CITY OF ALBUQUERQUE

Re: Cottonwood Classical GYM Addition & Classroom Renovation
7801 Jefferson St. NE
30-Day Temporary Certificate of Occupancy
Transportation Development Final Inspection
Architect's Stamp dated 09-17-21 (D17-D003A)
Certification dated 05-12-23

Based upon the information provided in your submittal received 05-12-23, Transportation Development has no objection to a 30-day Temporary Certificate of Occupancy based. This letter serves as a "green tag" from Transportation Development for a 30-day Temporary Certificate of Occupancy to be issued by the Building and Safety Division.

TRAFFIC CIRCULATION LAYOUT APPROVED
05/06/2022

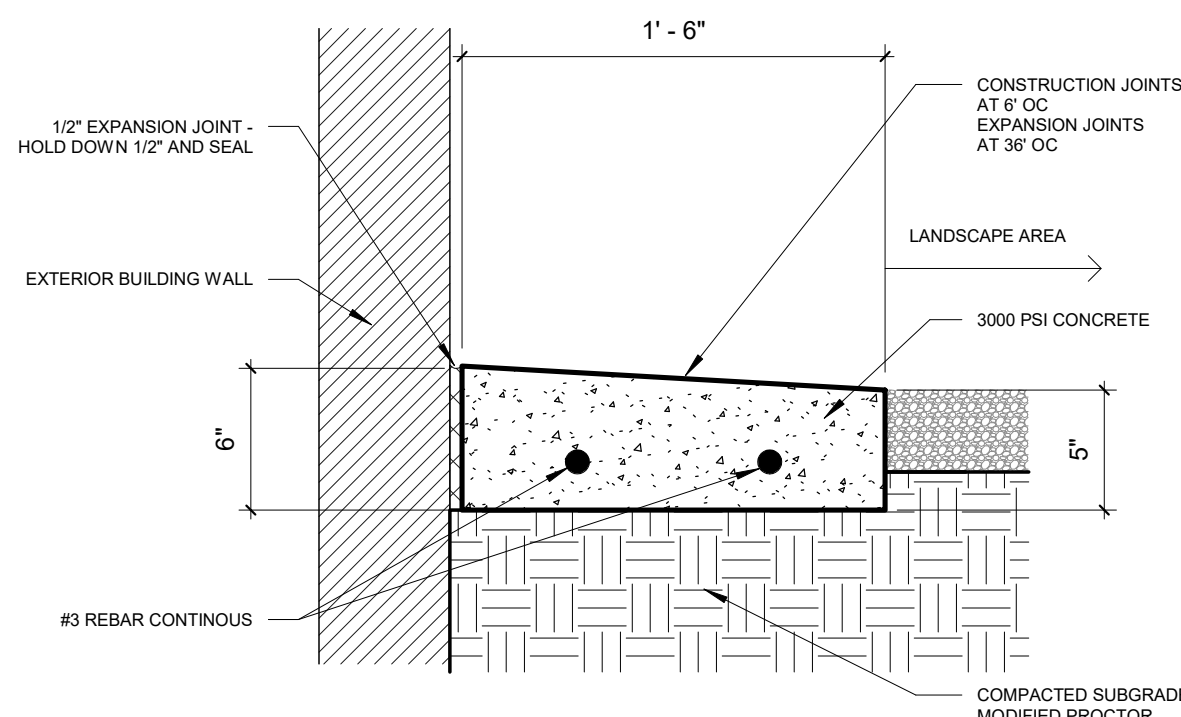
- Per approved plans, Truncated Domes must be installed on the ADA ramps at the site access off Headline Blvd. NE

Once these corrections are complete, email pictures to malnajjar@cabq.gov for release of Final CO.
